**Our Case Number:** ABP-317742-23

**Re:** BusConnects Bray to City Centre Core Bus Corridor Scheme  
Bray to Dublin City Centre.

**LOUGHLINSTOWN ROUNDABOUT TO WILFORD JUNCTION SECTION OF  
BRAY TO CITY CENTRE - BUS ROUTE 13**

Image 3.13: Section 3 Route Options Remaining After Stage 1 Sifting (Bray to UCD CBC Feasibility and Options Report (NTA 2017))

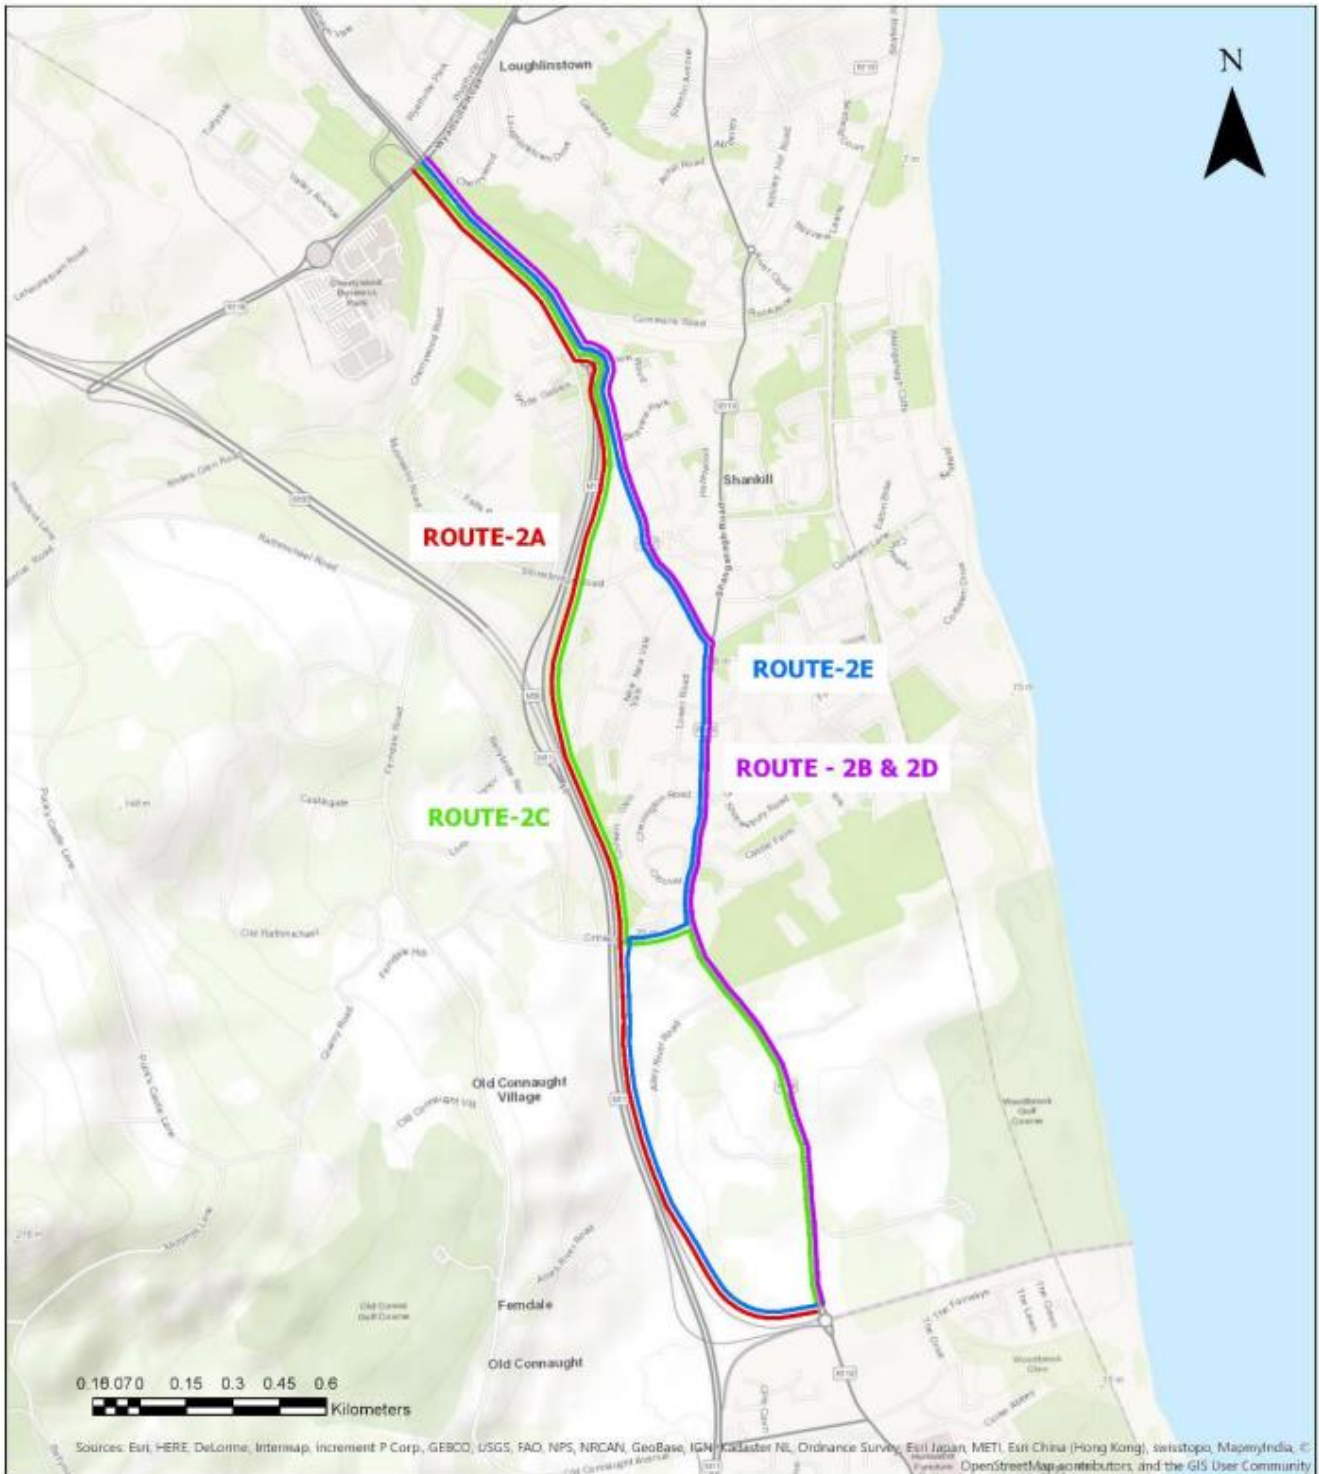
When Bus Connects Corridor 13 was first designed, a number of potential routes were suggested for the section from Loughlinstown Roundabout to Wilford Roundabout. One of these was Route 2A which followed a path adjoining the N11/M11. This was dismissed by the NTA although it offered the best journey time reliability and had significant environmental benefits.

The NTA has said from the start that Route 2B, the chosen Route, was far from optimum, with journey time savings less reliable on this route than on their proposed Route 2A. See Appendix 1 for extracts from the Original Background Research carried out by the NTA when considering possible routes through Shankill.
